M4-M5 SSI-7485-Mod-2 ROZELLE INTERCHANGE COMMUNITY COMMENT

Key issues:

Figure 4-3 The Crescent, Johnston Street, Chapman Road intersection options

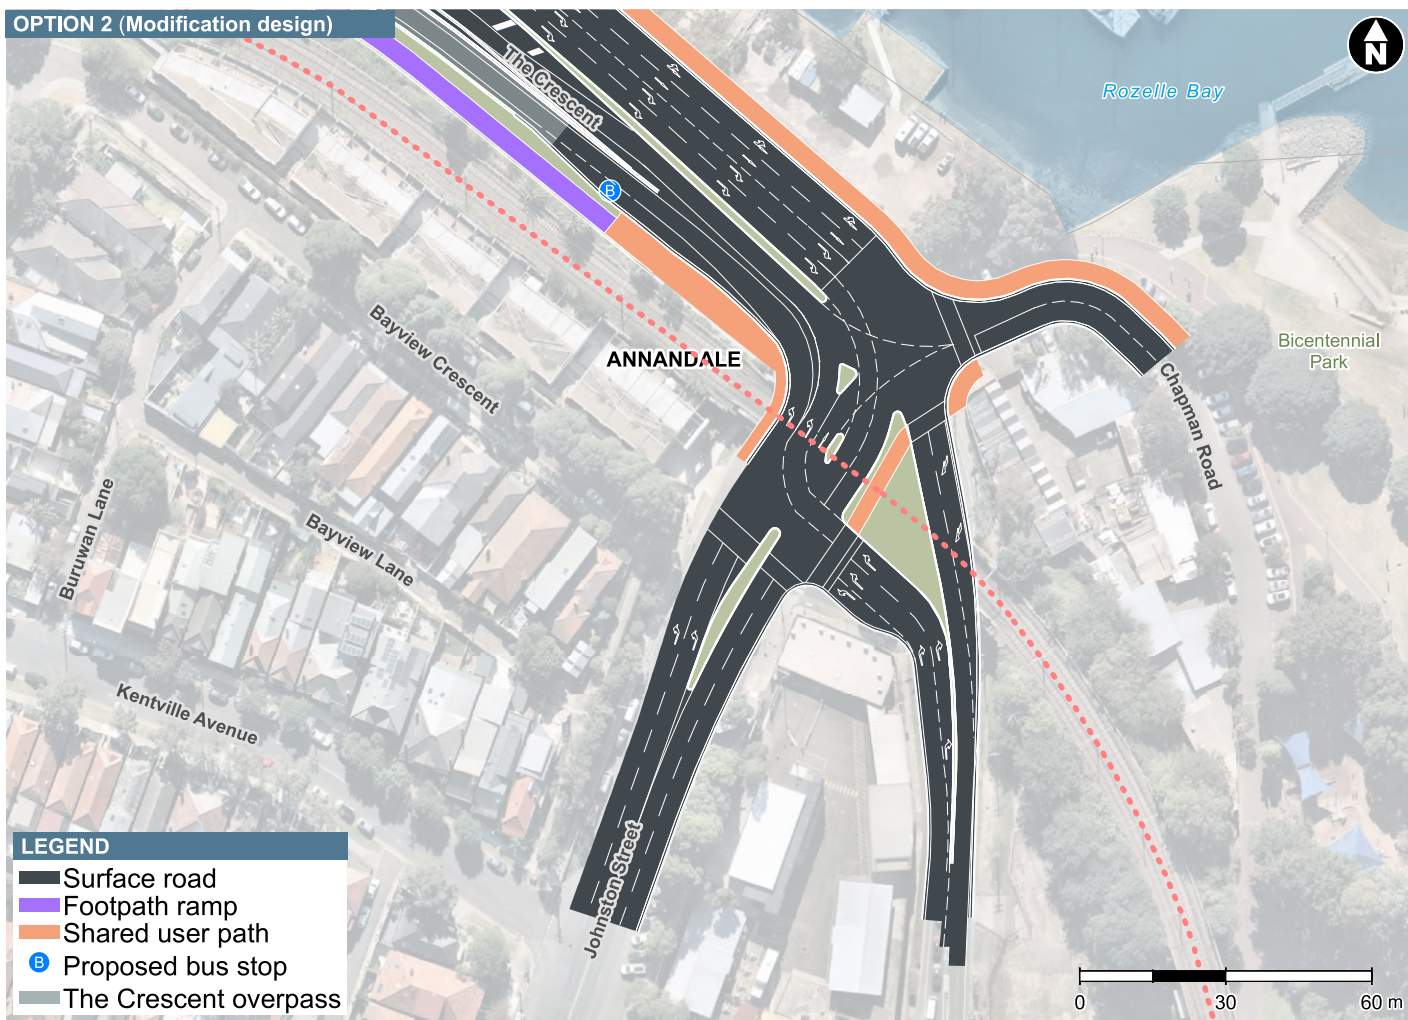
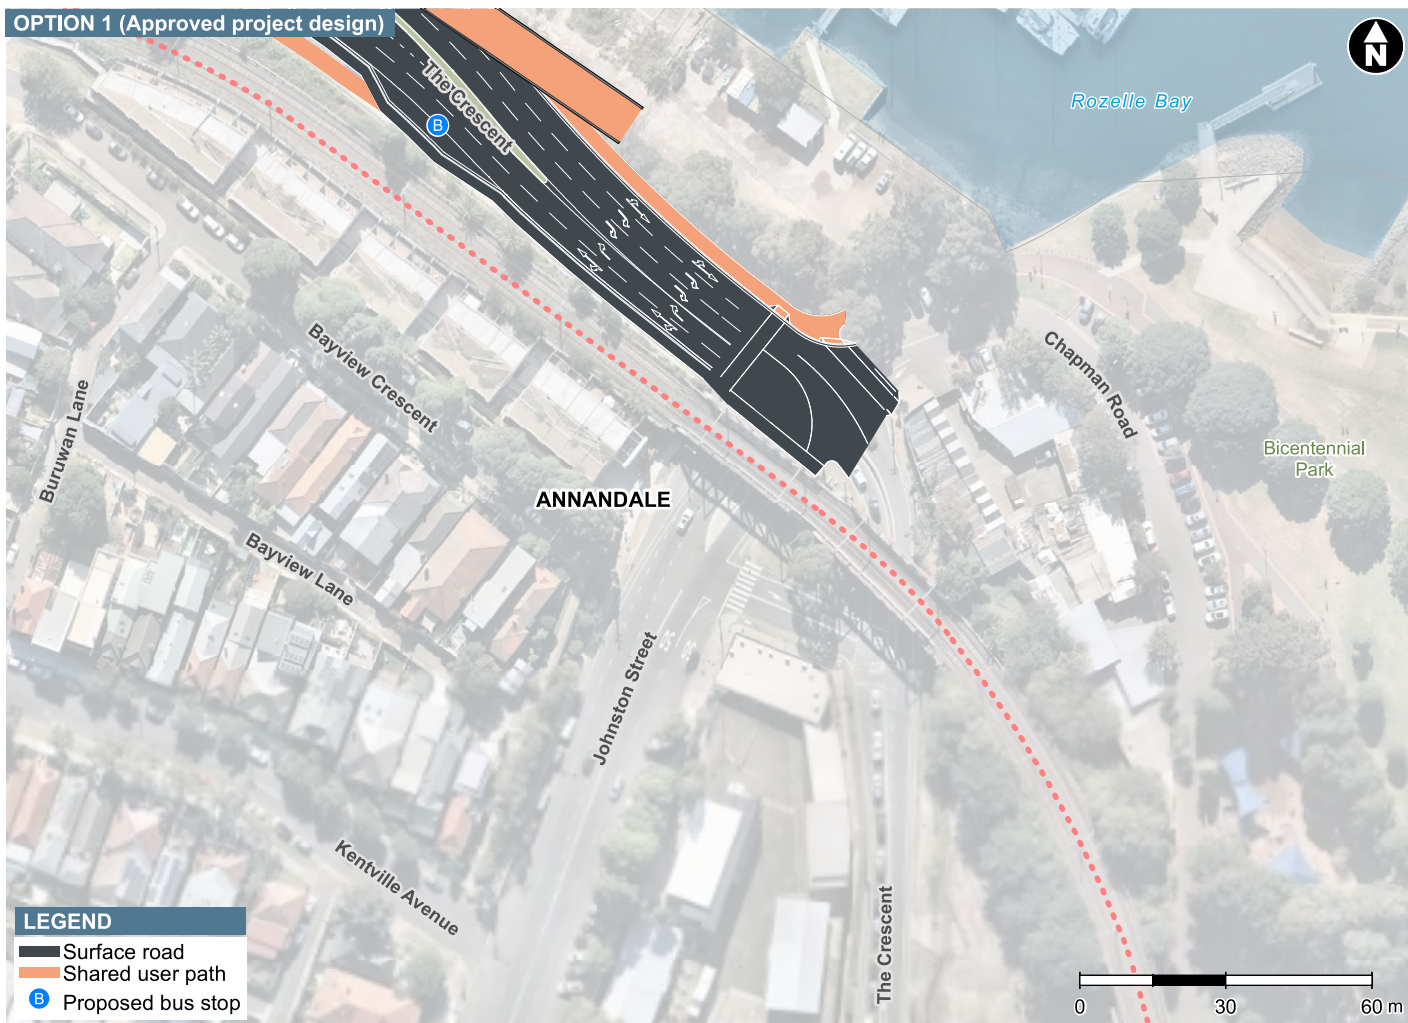
Review Option 1 in terms of traffic light phasing. This option provides maximum traffic movement options. Most of the issues stem from the width / heritage constraint at the Crescent/Johnston Street.

Simplification of the Johnston Street crossing of the Crescent. Change to a single traffic light crossing in the current location on the Northern side of Johnston Street as currently exists.

Figure 4-4 Elevation: Indicative view of The Crescent overpass

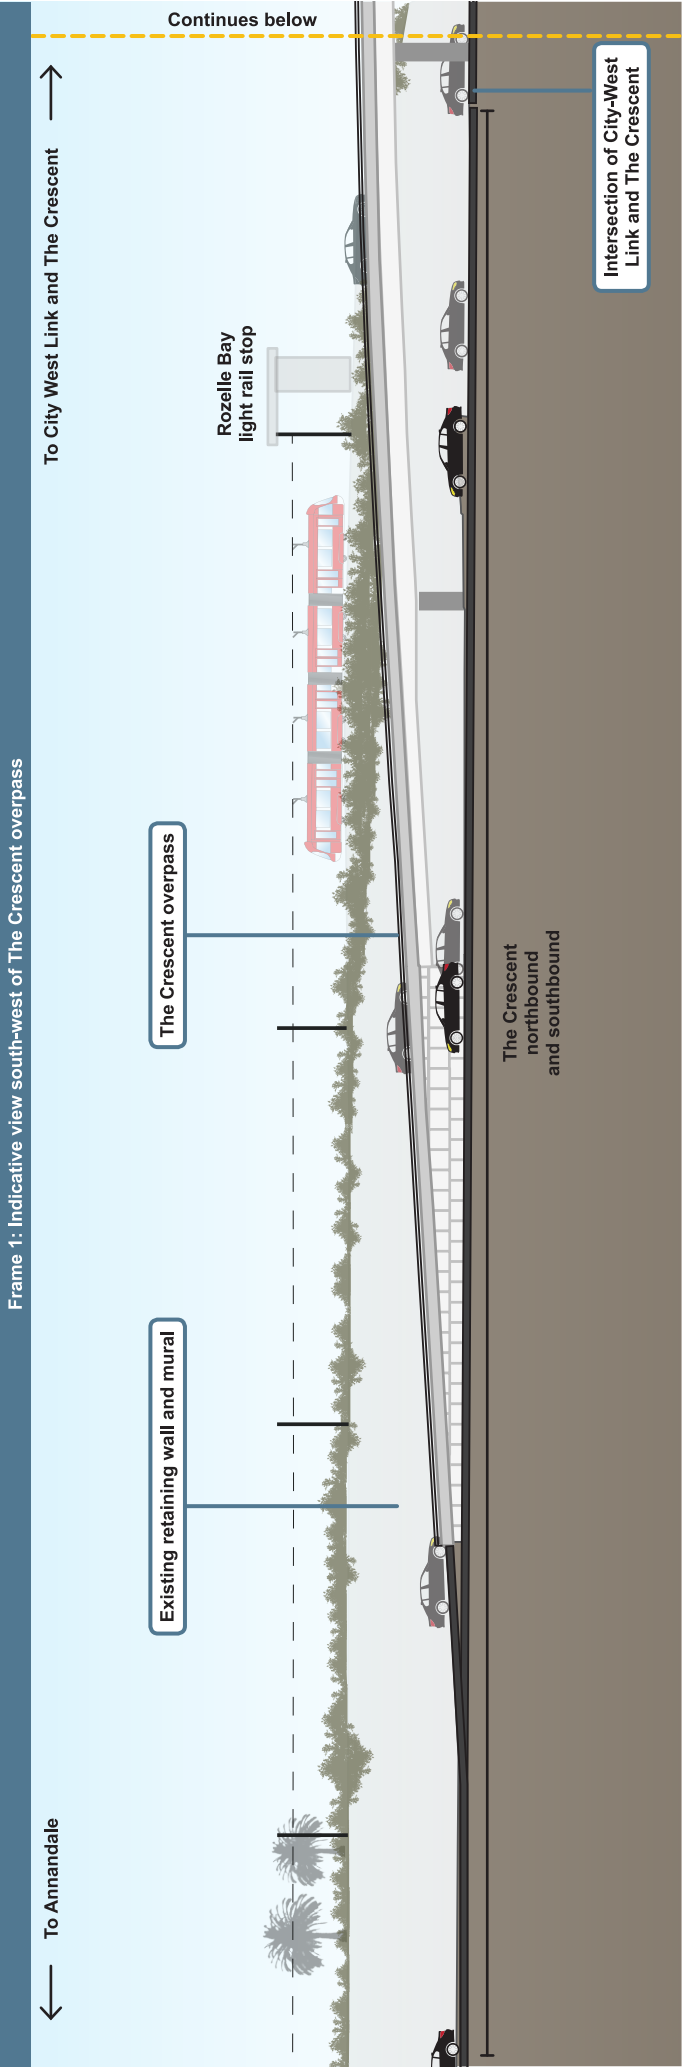
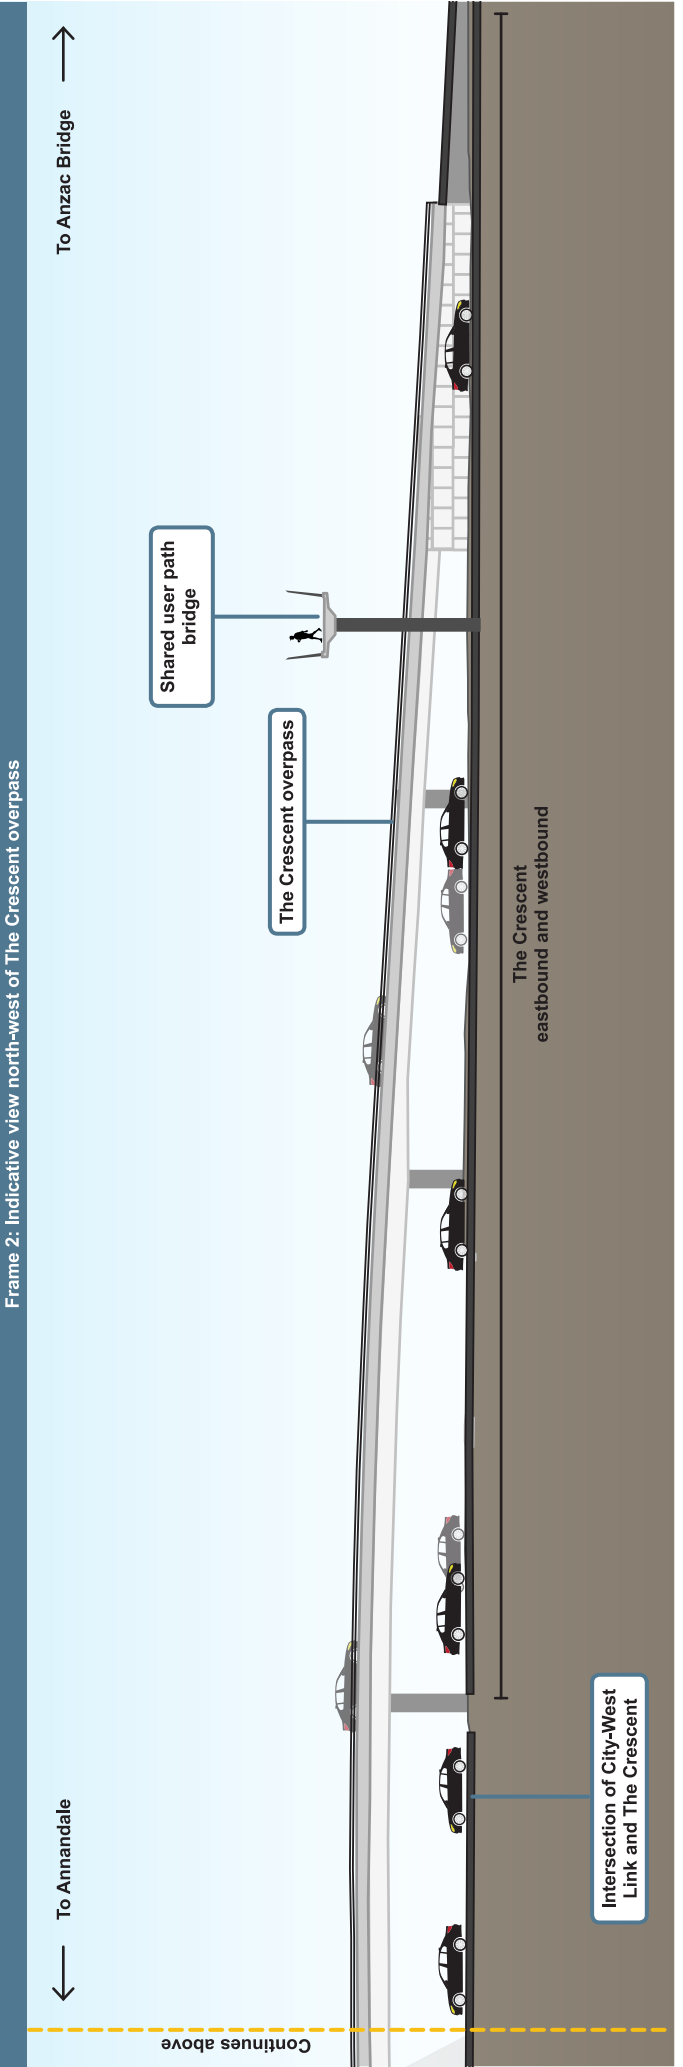
Key issues with the overpass

The overpass has been driven by level of service issues. However it is only improving it from F to C, and is likely to degrade further over time. Both option 1 and 2 were better urban outcomes.

It has significant visual impact issues itself. Its design speed is making it higher than the Green bridge. It blocks views to the harbour from the relocated green bridge. Light poles will further add to its visual height. It also impacts the mural.

The 165m tunnel option 2 was discarded due to constructability and other concerns. Options to simplify it by limiting the tunnel to 120m should be addressed. The long length drives a requirement for mechanical ventilation, and therefore a deeper trench and a longer tunnel, all adding greatly to the cost. Option 2 needs to be revisited.

Remove the overpass. Return to option 1 at grade intersection or solve underpass option 2 technical constraints as the preferred option.

Figure 4-5 The Crescent/Johnston Street/Chapman Road intersection

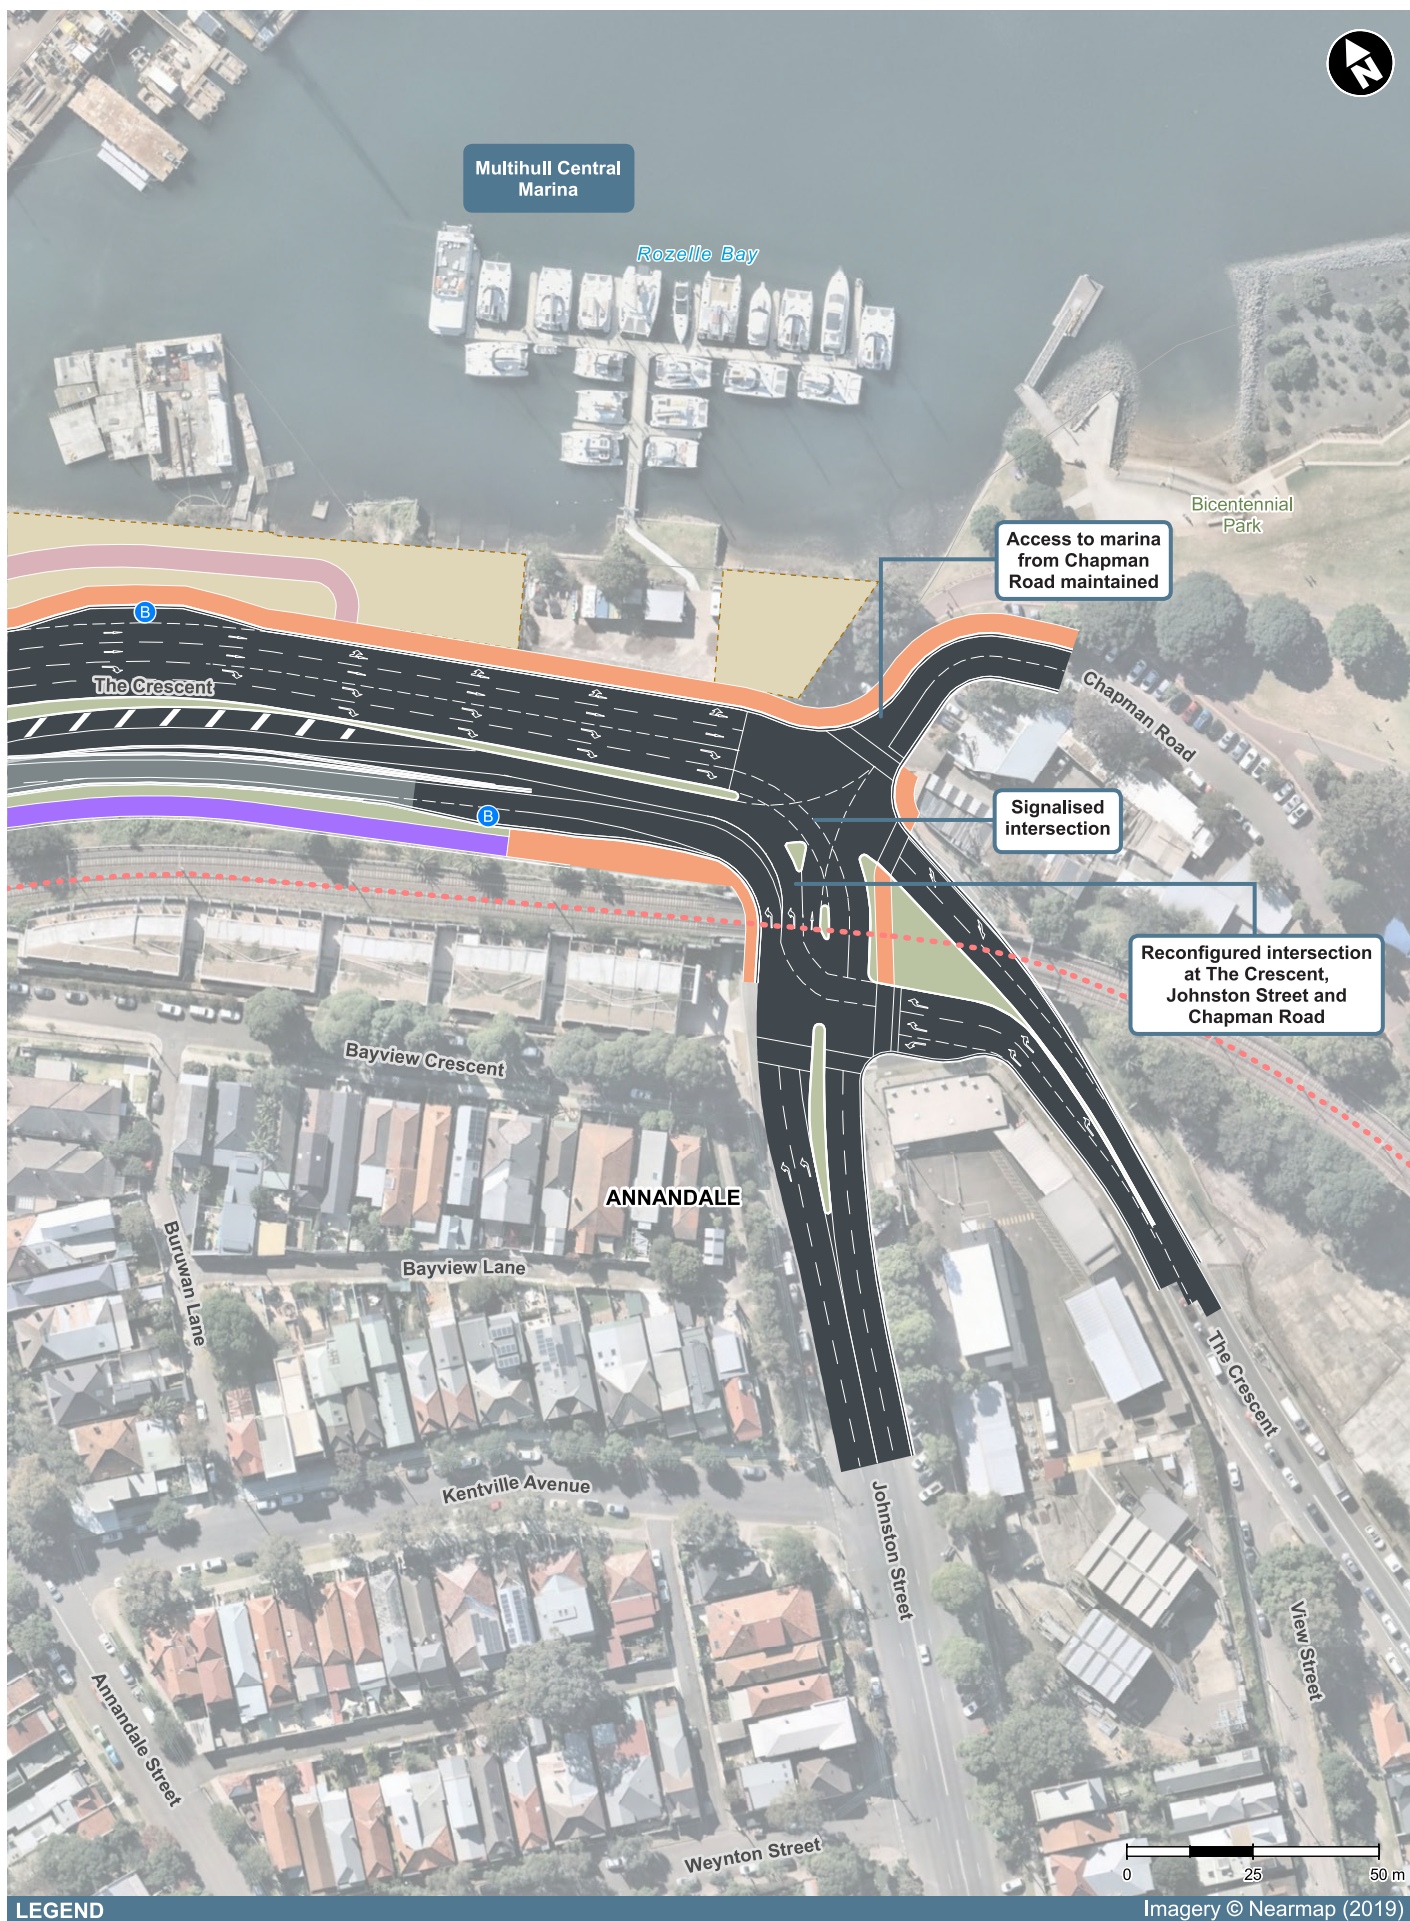
Consider options to retain the right turn lane from Johnston Street to The Crescent in the redesign of the pedestrian intersection and location of the traffic lights.

Figure 4-6 Elevation: Indicative view of Rozelle Rail Yards Pedestrian and Cycling Green Link

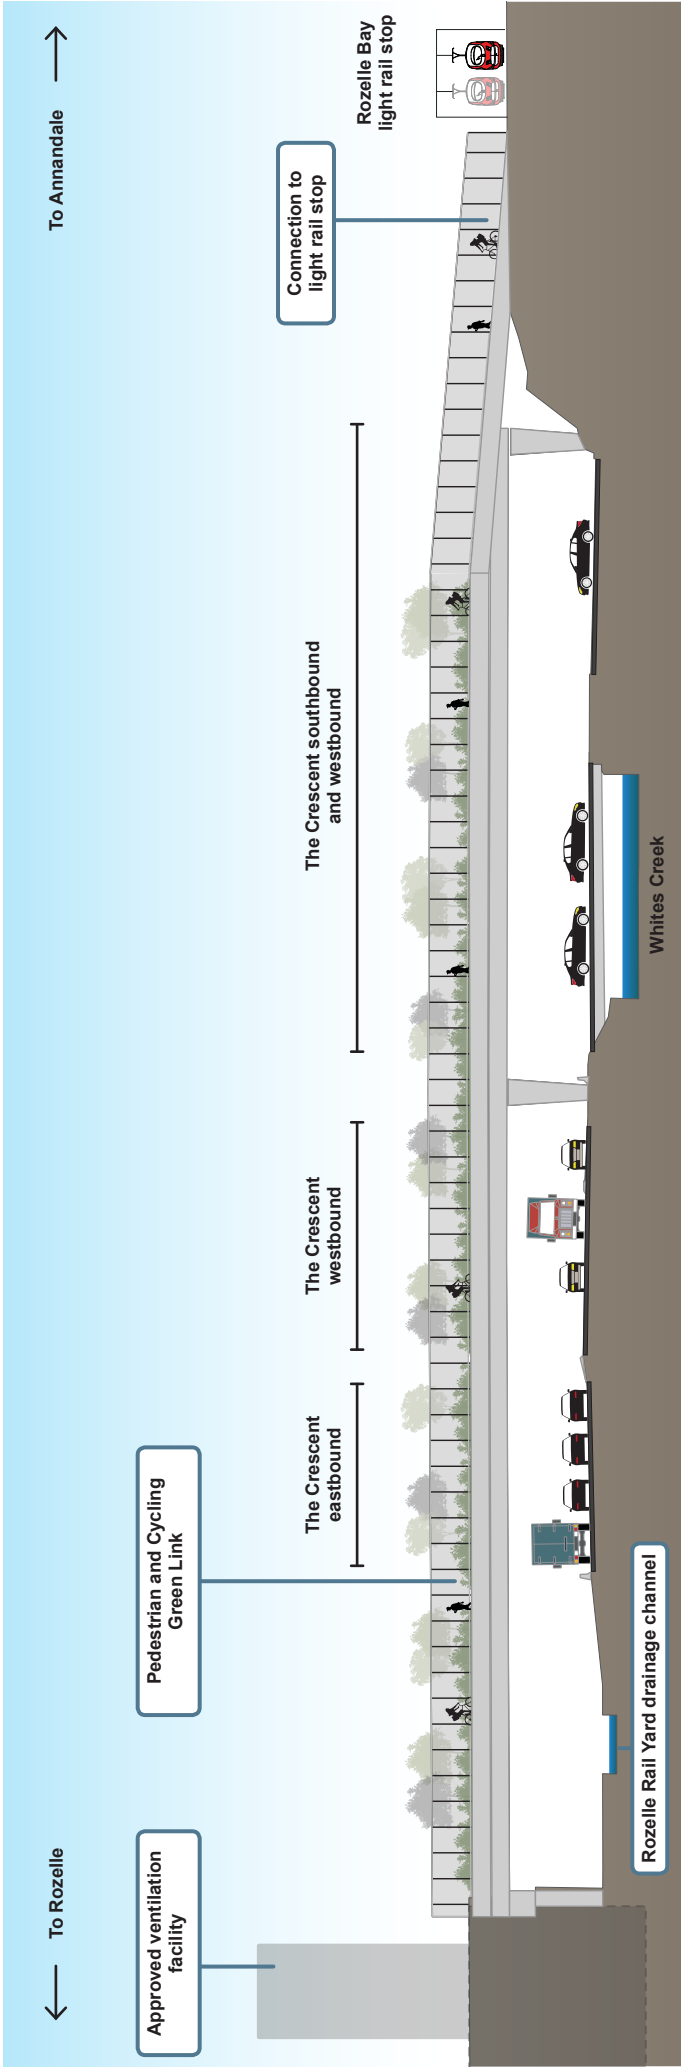
Green Bridge
removes edge
vegetation

Green Bridge
not very green

Overpass
blocks views
from Green
Bridge
